CITY OF ALBUQUERQUE

**Re: Assisted Living Home, 7500 Oakland Ave NE
Grading and Drainage Plan
Engineer's Stamp Date 1-12-15 (C19/D062)**

Based upon the information provided in your submittal received 1-13-15, the above referenced plan cannot be approved for Site Plan for Building Permit action by the DRB until the following comments are addressed:

ASSISTED LIVING HOME
LOT 13, BLOCK 3, UNIT 2, TRACT 2, NAA
GRADING & DRAINAGE PLAN

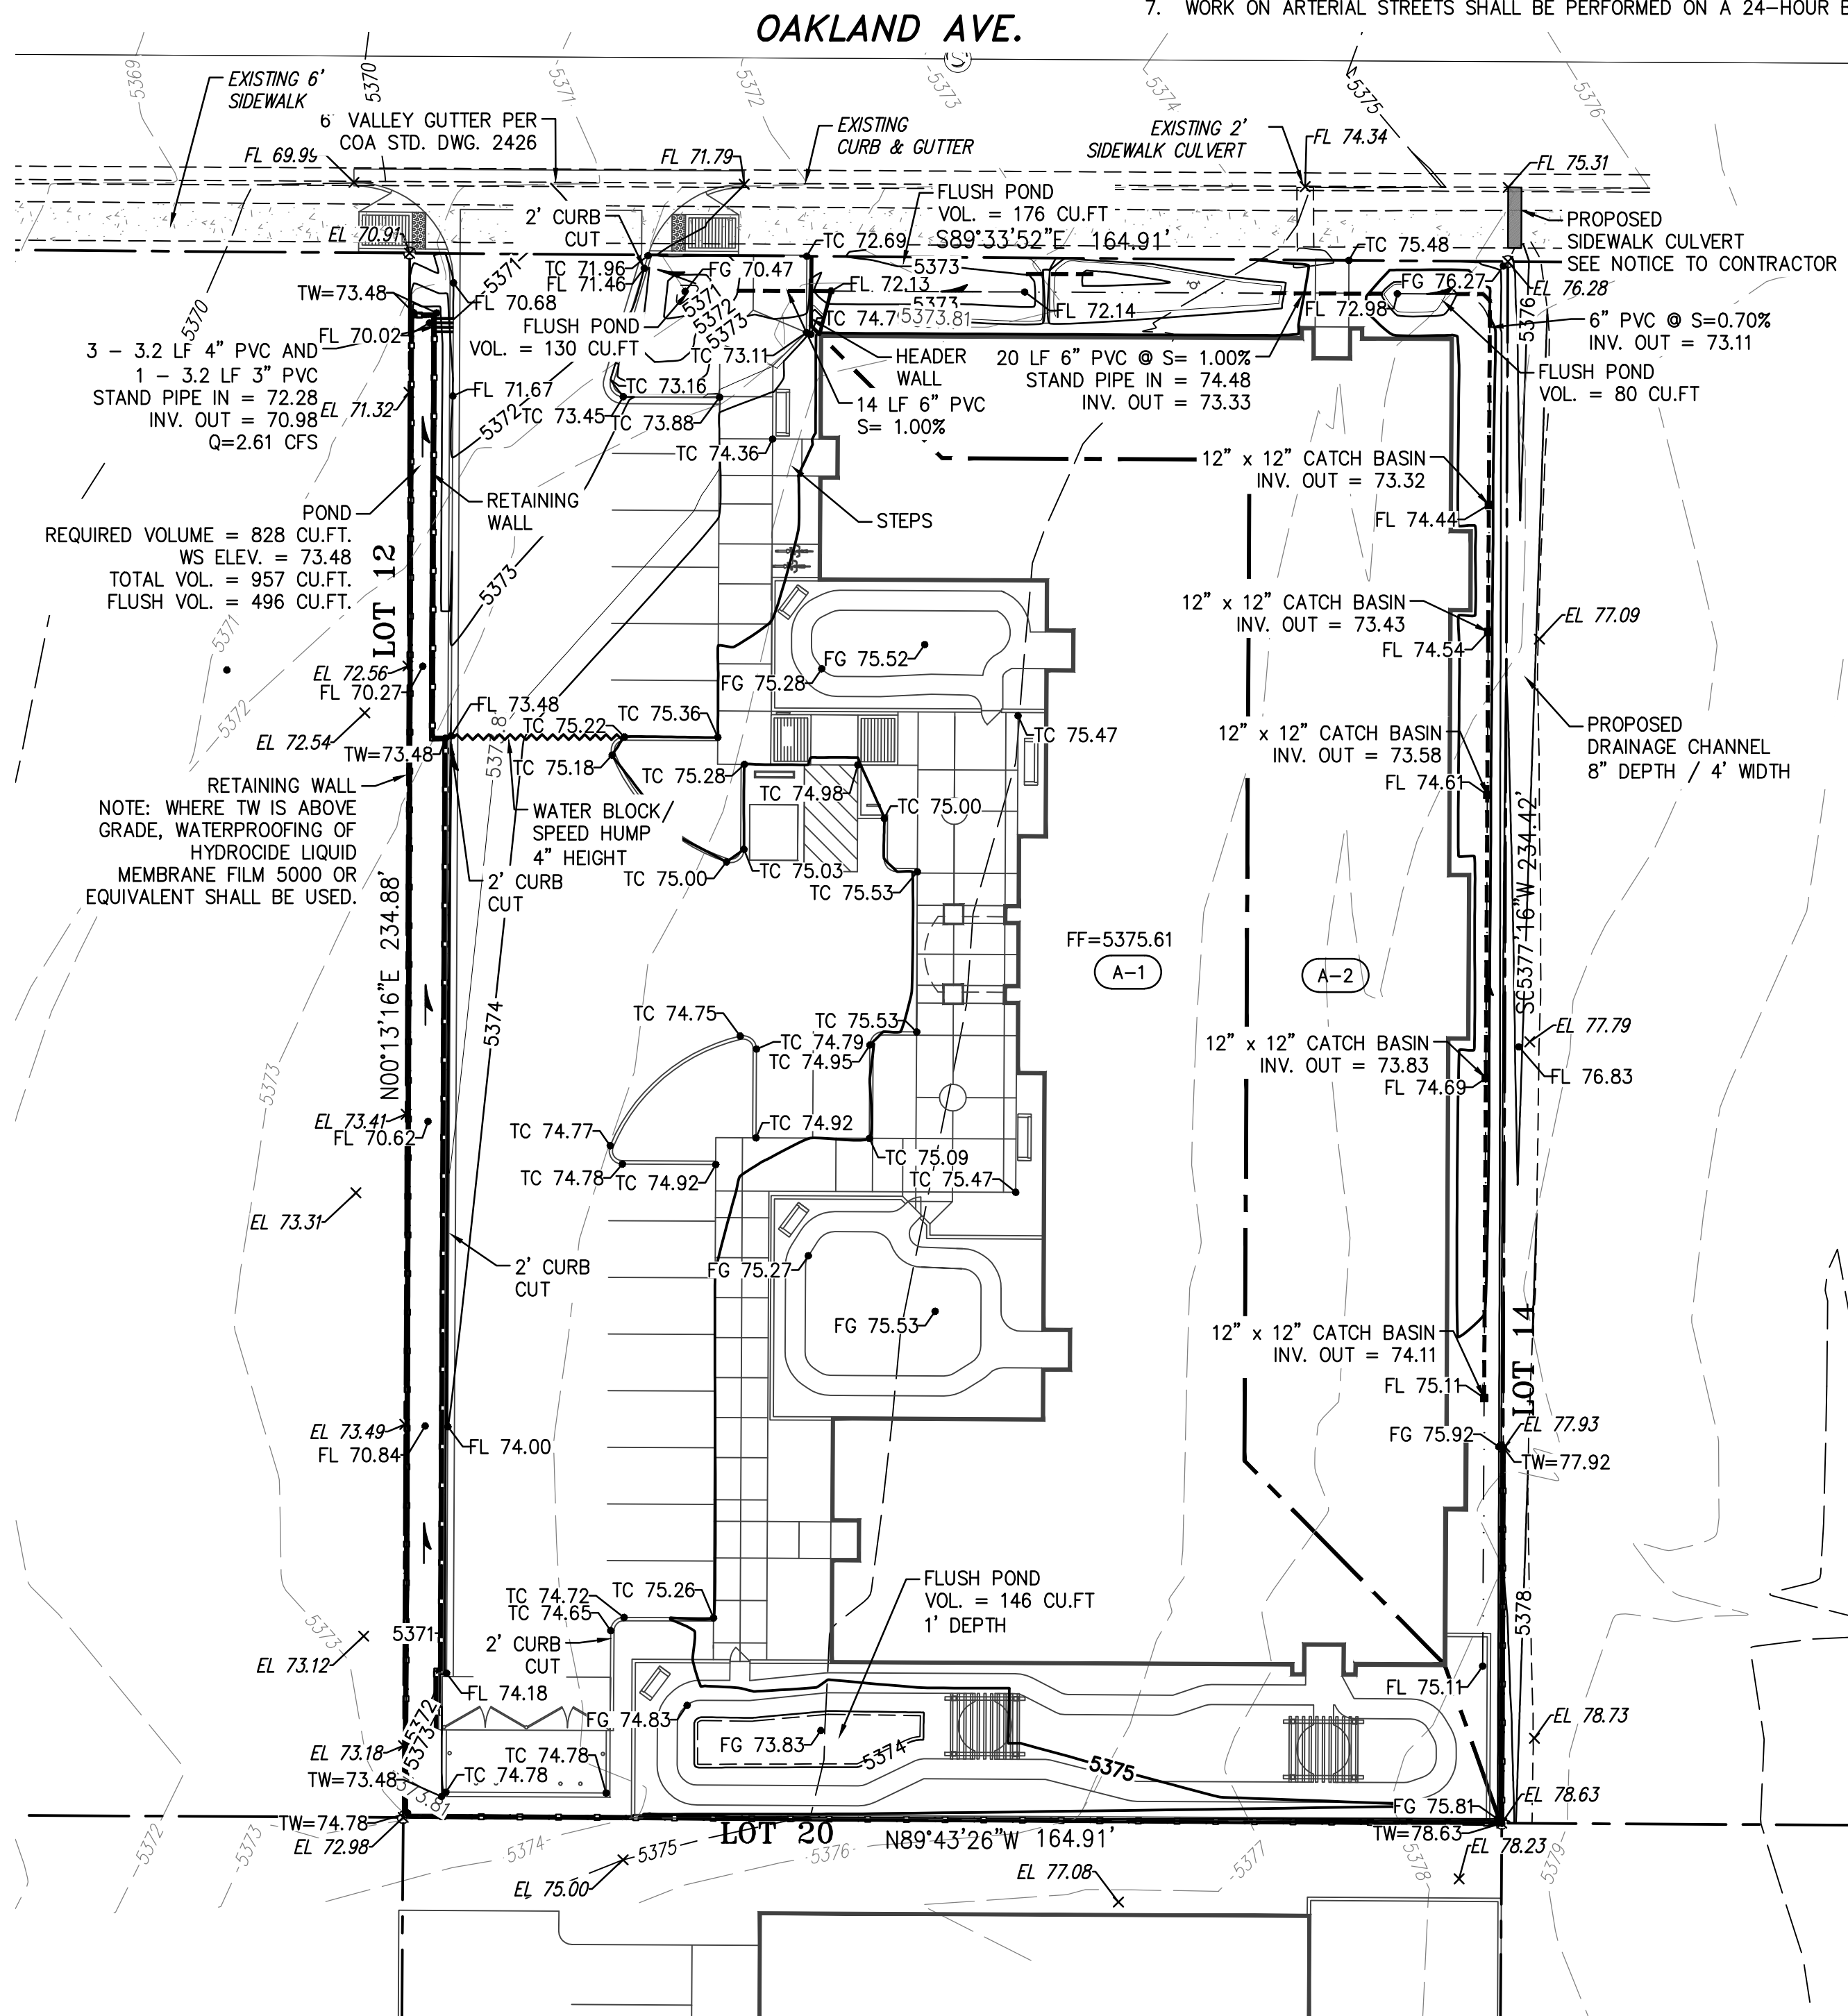
1. The plan is to address and quantify offsite flows. The City recently constructed a sidewalk culvert in Oakland Ave (shown on your plan) to accept flows from the northern basin of the site to the east. These flows are to enter Oakland Ave, without flowing over the sidewalk.

2. There are also offsite flows which appear to enter the southern area of this site which are to be addressed, quantified and accepted.
3. Per the NAADMP this site is allowed 50% impervious area. It proposes more than that. It appears a detention pond will be required. In addition, Quail Springs Estates constructed a 15" storm drain in Oakland Ave. The construction plans show a flow of 12 cfs. The drainage plan is to address how it complies with the NAADMP and the Quail Springs Estates drainage report.

4. Provide existing contours.
5. The plan is to manage the first flush and state how it is doing so. Provide calculations for the first flush volume.
